From: Maria Tomalova
Sent: 23 August 2019 15:24
To: Planning.Responses
Subject: FW: BR/239/18/PL, 9 London Road
Attachments: 20190821 9 London Road PA.pdf

From: Look. design + build [REDACTED]
Sent: 22 August 2019 11:04
To: Maria Tomalova [REDACTED]
Subject: Re: BR/239/18/PL, 9 London Road

EXISTING GROUND FLOOR

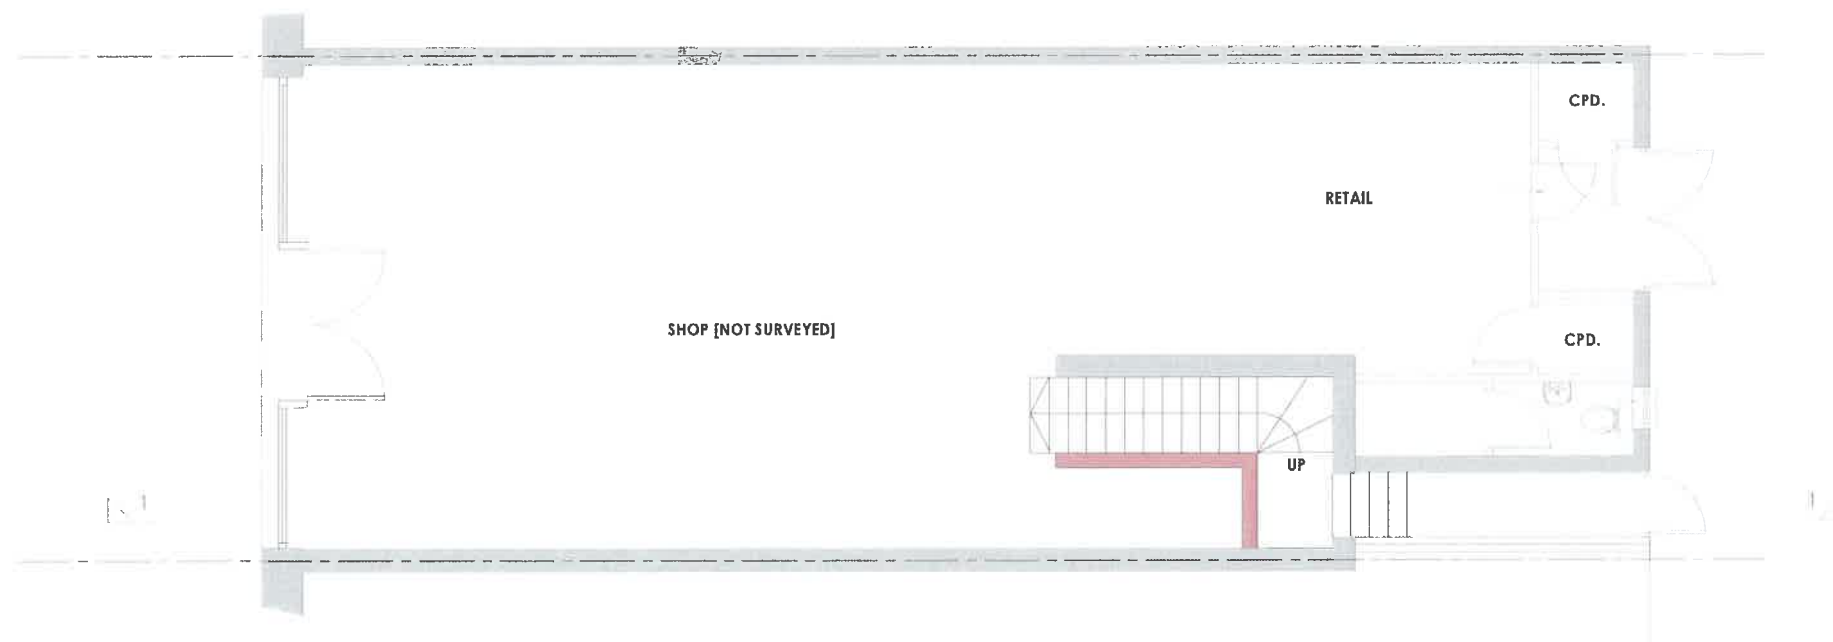
Show me every floor within one sheet as existing and as a proposed (ground, first, second)
and a rear elevation (I am not happy with that submitted).

Please see attached amended plans. We trust these are now acceptable. Many thanks.
